From: Clare Dales
Sent: 21 March 2018 09:00
To: Ross Leal
Cc: Martyn White
Subject: RE: Please find attached amendment on planning application Ref: CM/30/17/L

APPLICATION **CM/30/17/L**
NO:

Registered: 28-NOV-17
Site Address: The Dairy Brookpit Lane Climping BN17 5QU

Description of Works: Listed building consent for new front door, porch roof over, remove internal wall on first floor, new ballustrading on first floor, new internal window on ground floor & removal of partition walls on ground floor.

Job Title	The Dairy Brookpit Lane, Climping		
Client	Antoinette Wilks		
Drawing Name	Plan and Elevations Proposed		
Drawing Status	Planning		
Drawn by	AF	Date	Aug 17
Checked by		Date	
Drawing Scale	1:100 at A2		
Drawing No	171128/	Status	02
		Revision

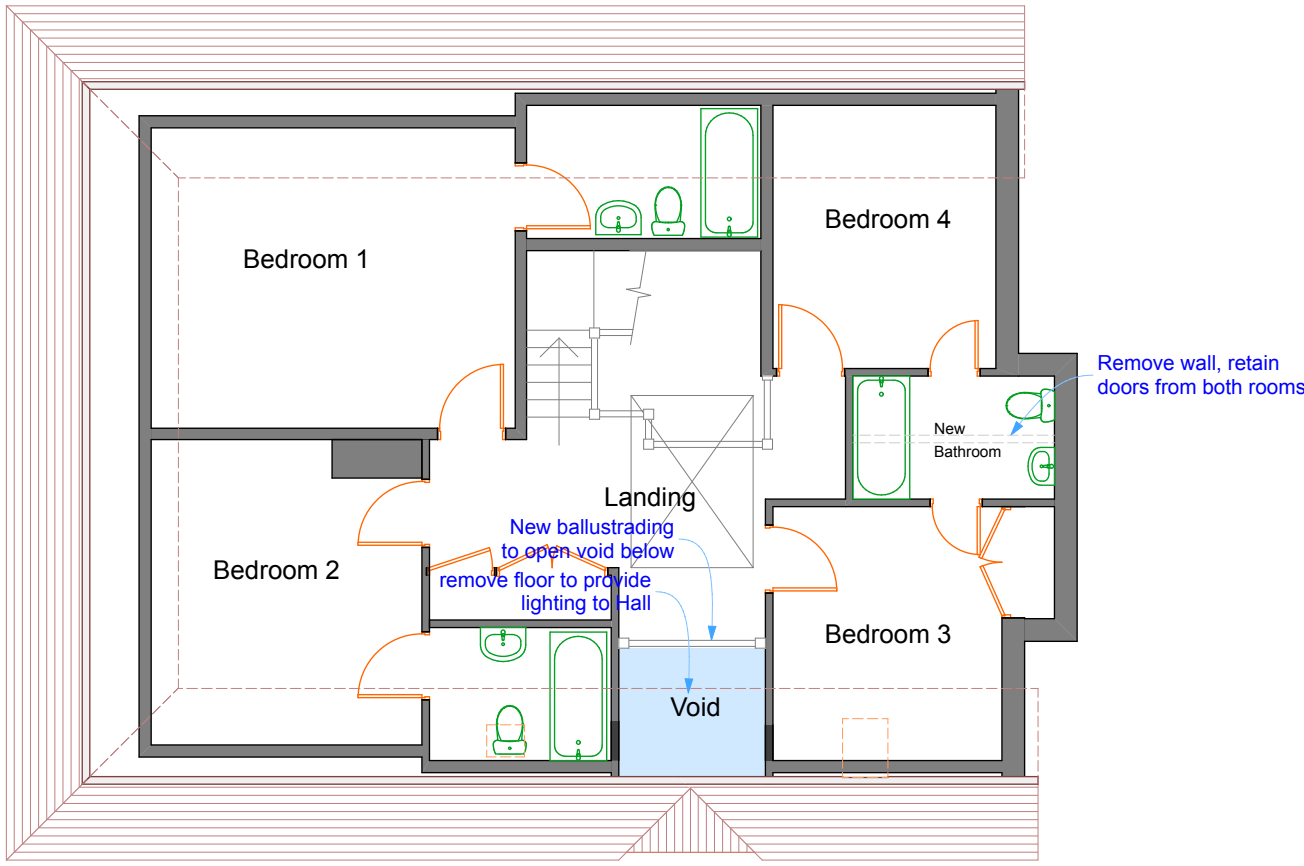
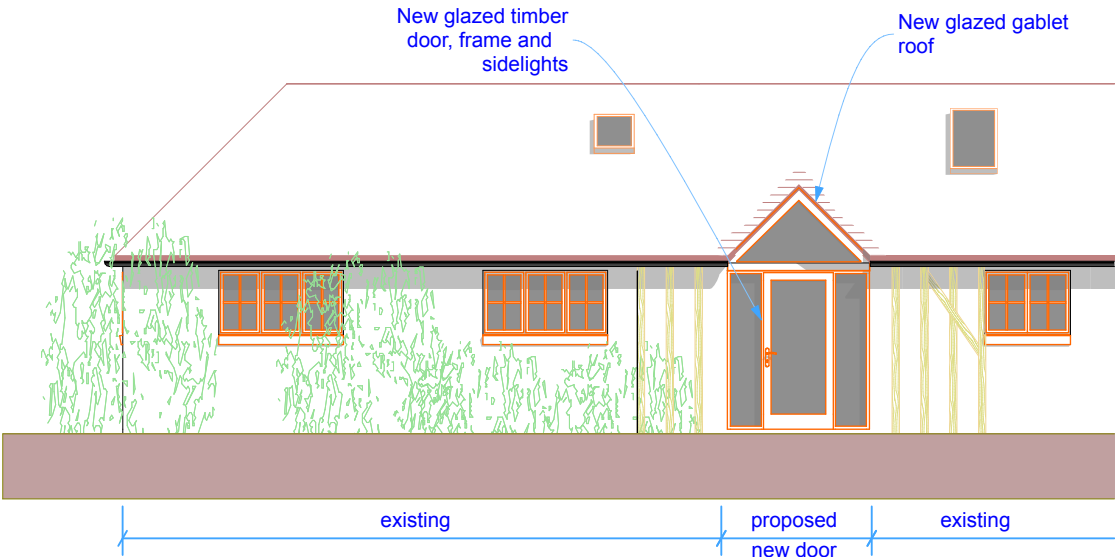
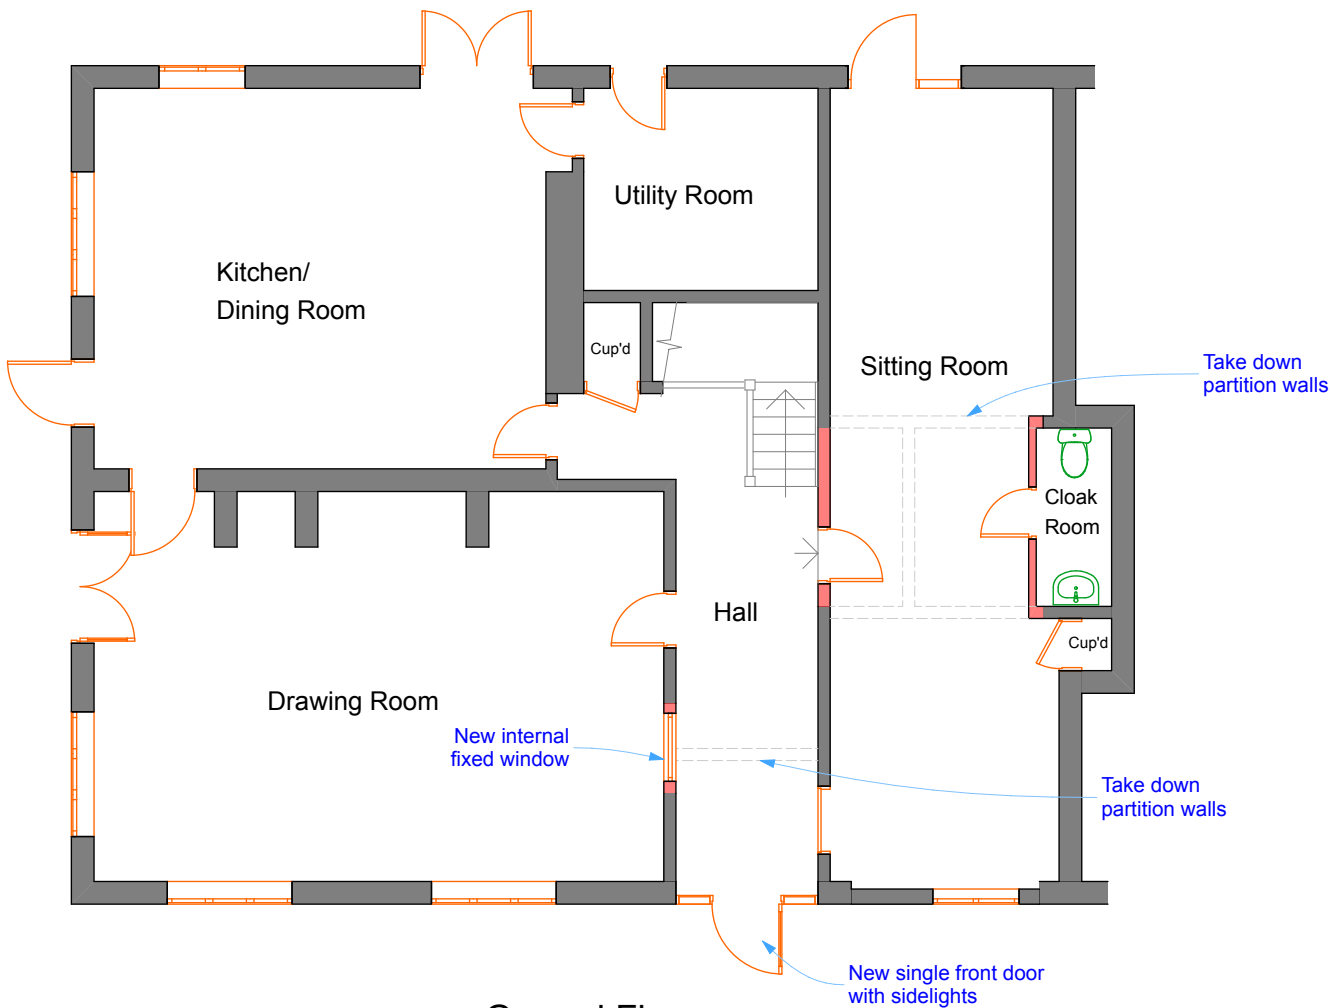
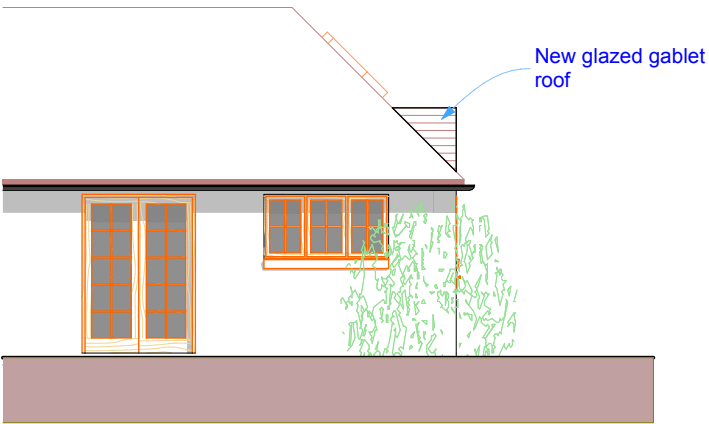
Thank you for inviting me to comment. I find the revised plans regarding the proposed internal works and new door acceptable as detailed (subject to condition, including joinery design and finishes). I note, however, that there is no mention of roofing works. This is essential to halt the ingress of water to the building, as described/shown to me during my last site visit. I was expecting this to be part of the application, and not it is omitted. Any roofing works would need LBC.
